Subject: Christian Brothers Automotive (PPR183)

The Planning Division of the Community Services Department has reviewed the Christian Brothers Automotive Site Development Plan / Special Use Application and has the following comments on behalf of El Paso County Parks.

**SECTION A-A PROFILE
STA 0+00.00 TO 0+40.00**

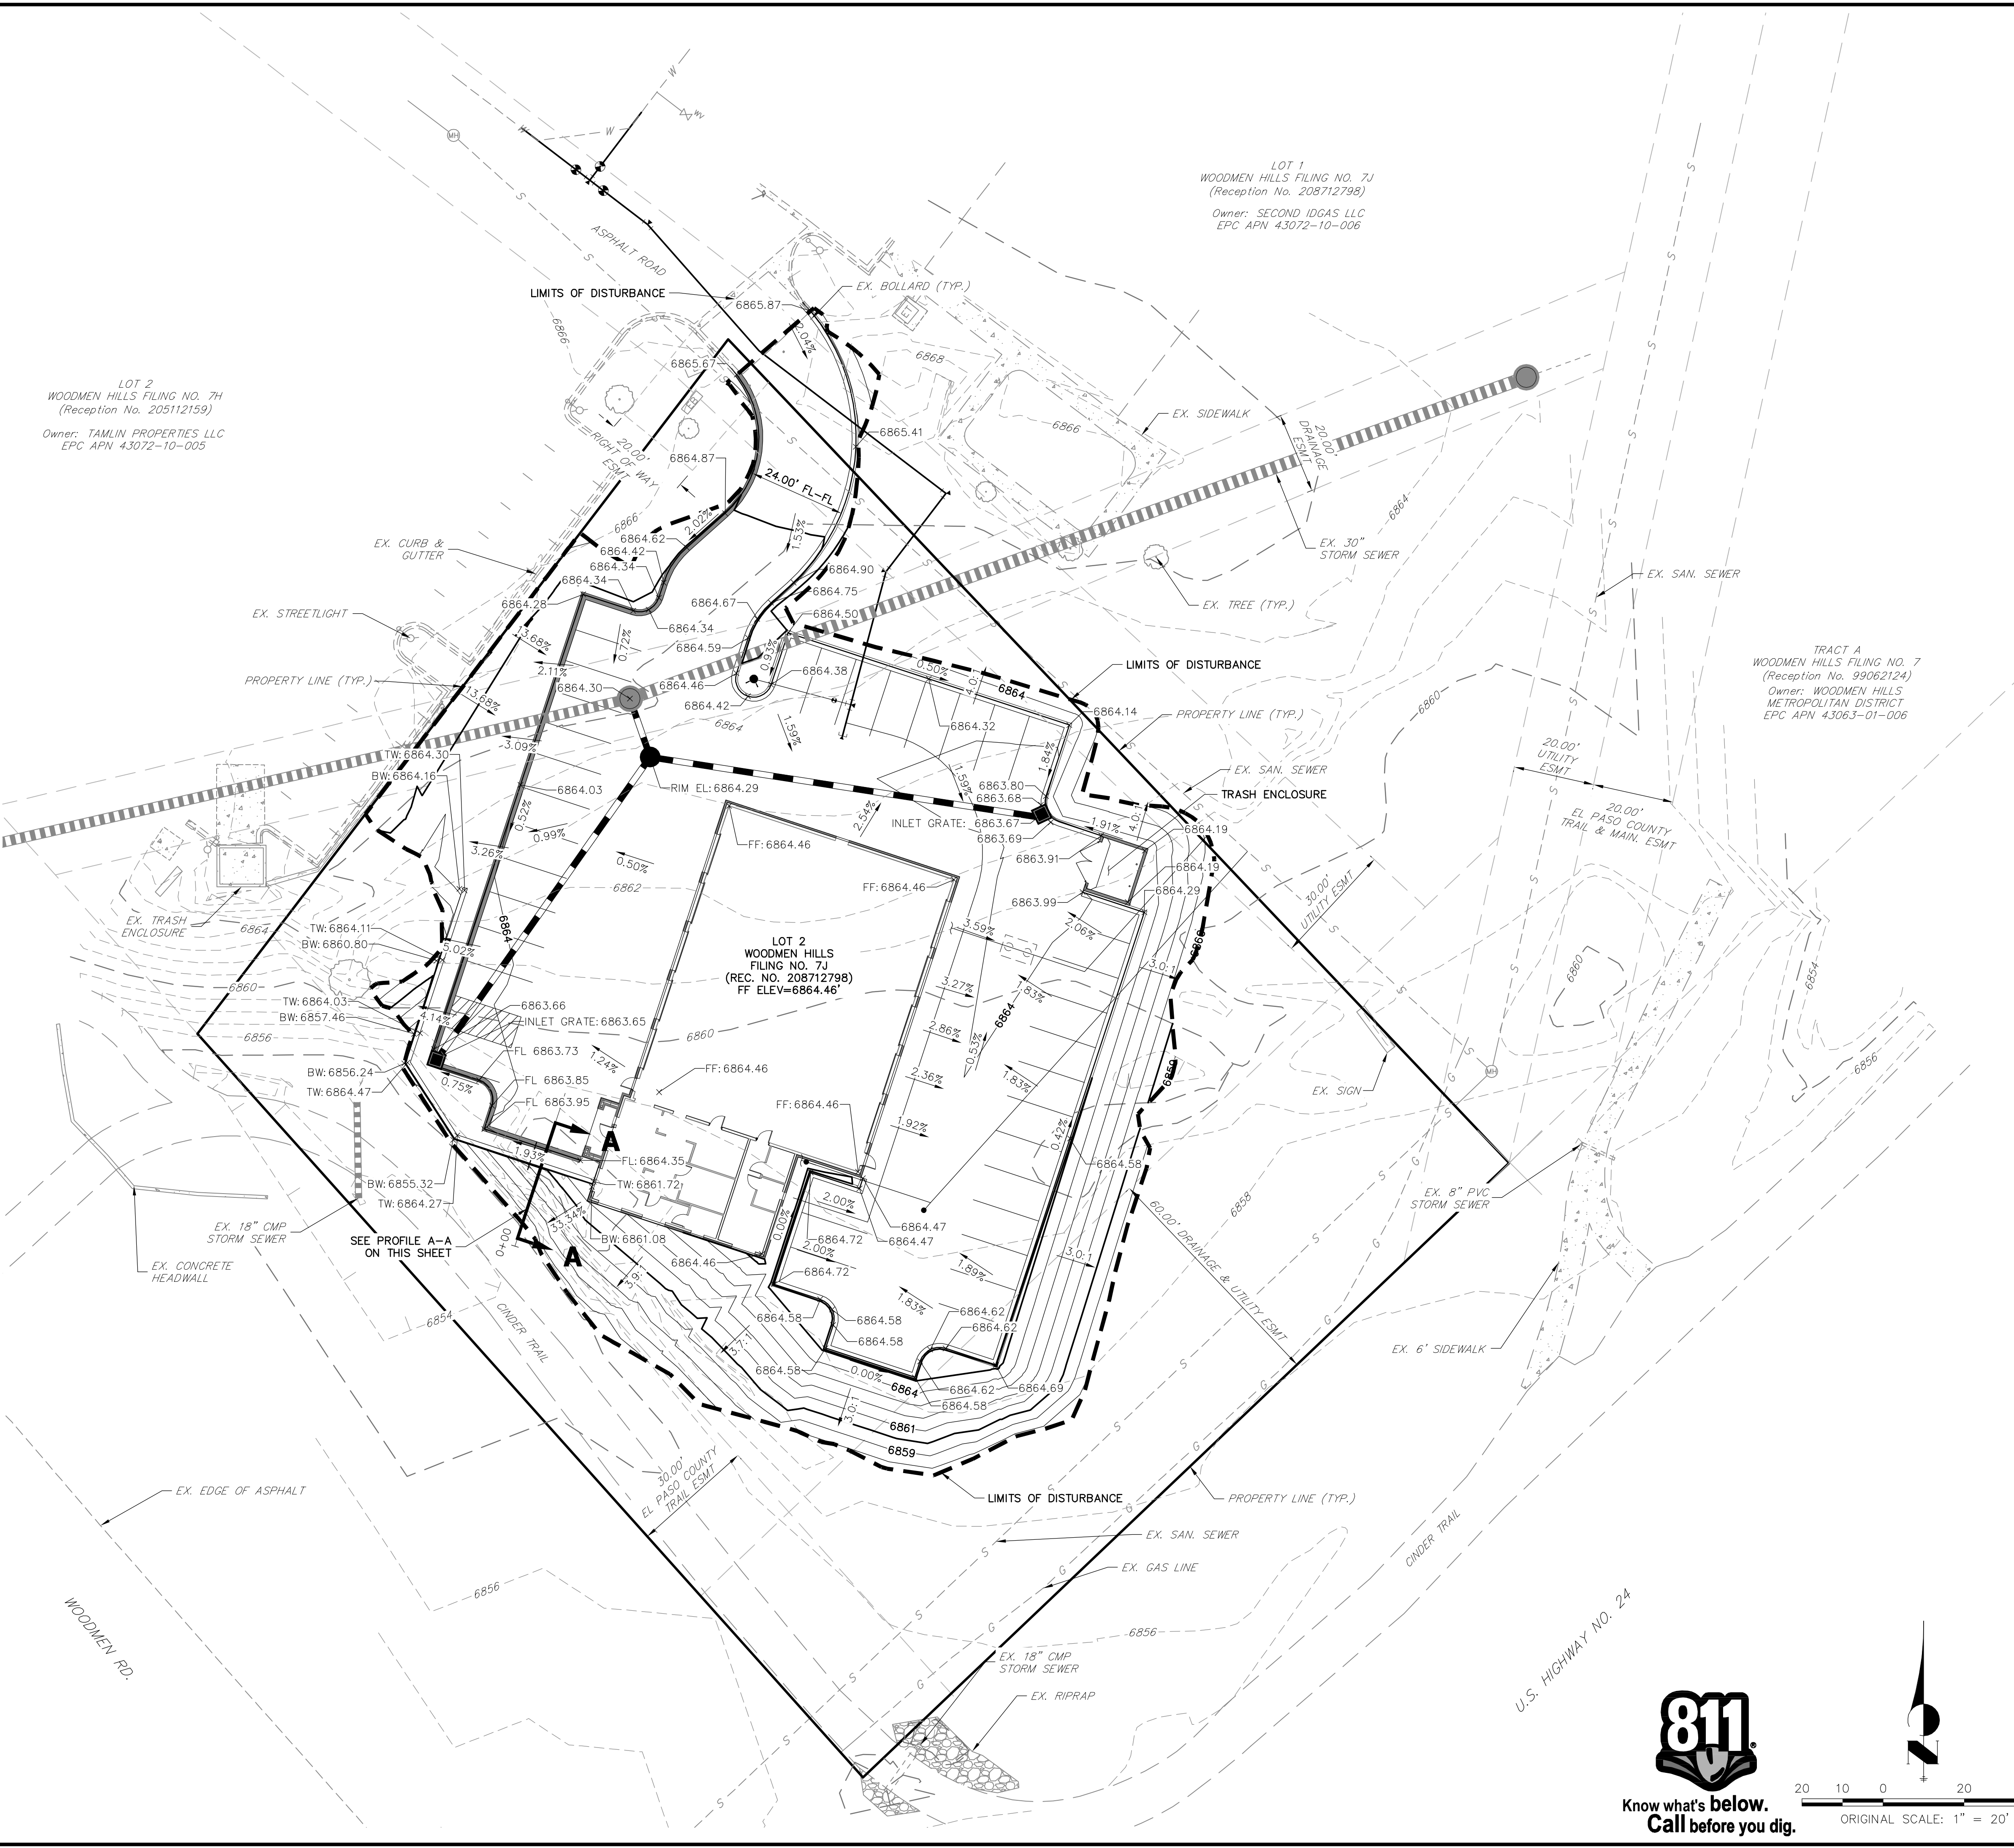
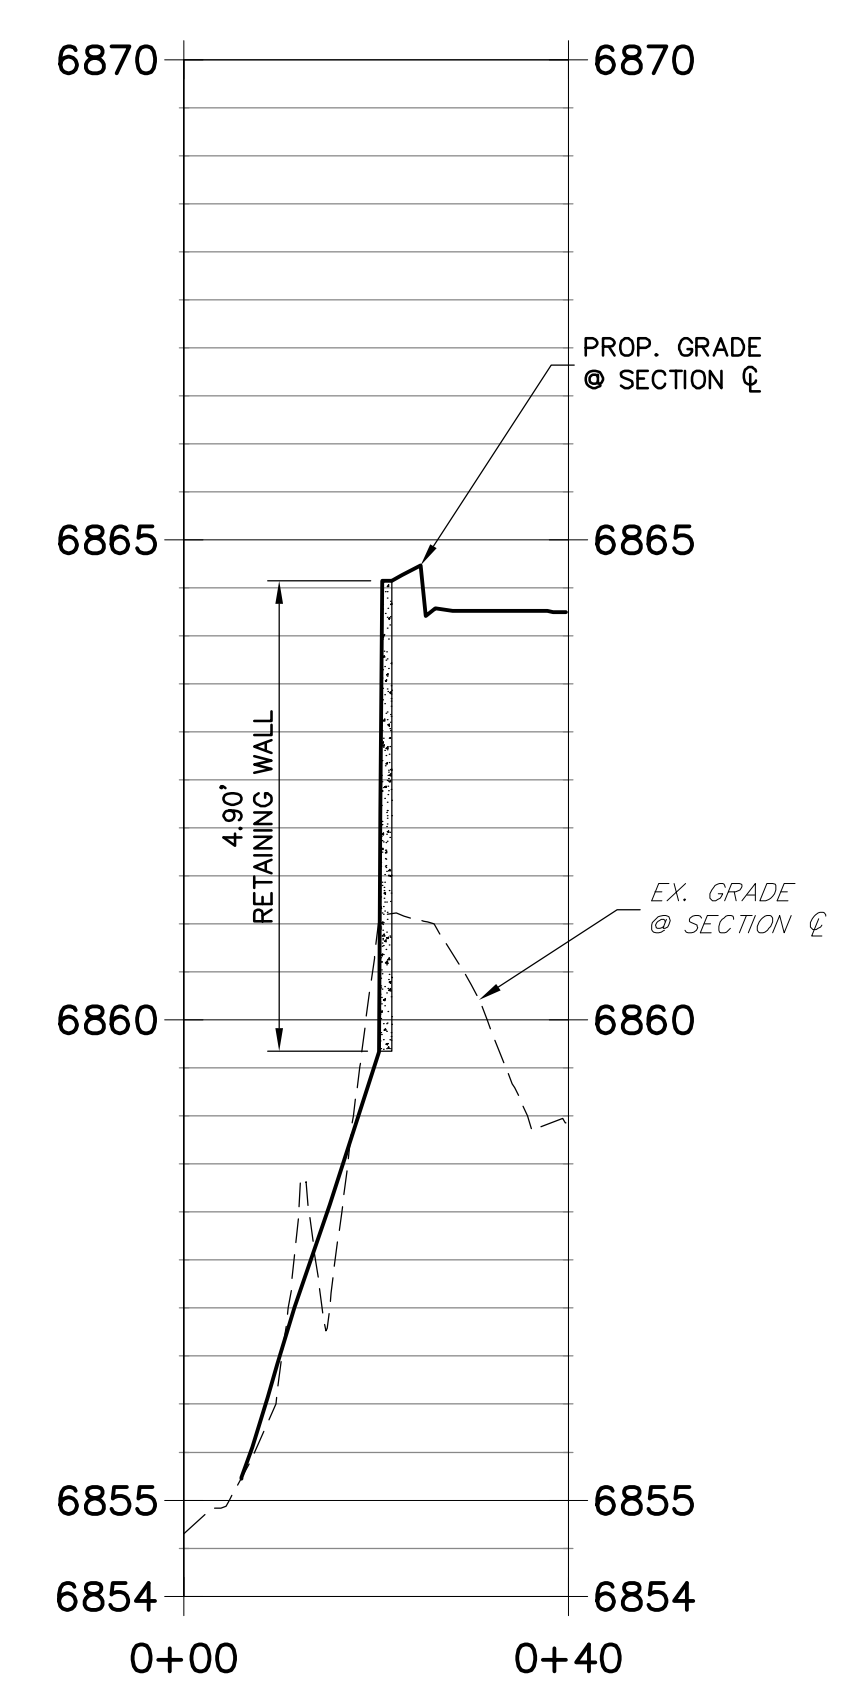
The preliminary grading plan shows a retaining wall to be constructed just within the trail easement. Construction of the wall will most likely include the installation of a heel drain and toe drain which could direct stormwater runoff towards the trail. The plan also includes increasing slopes in excess of 3:1 directly adjacent to the trail easement. Furthermore, it appears a drainage swale is incorporated into the slope leading from the building between the parking lot and lobby/sales area to the south. Staff has concerns that installing the retaining wall and increasing slopes will increase the probability of stormwater runoff onto the trail. To mitigate this risk, staff requests the applicant install a grass-lined ditch running

adjacent to the trail, within the trail easement, to properly drain runoff to the storm sewer located just east of the Woodmen Road underpass.
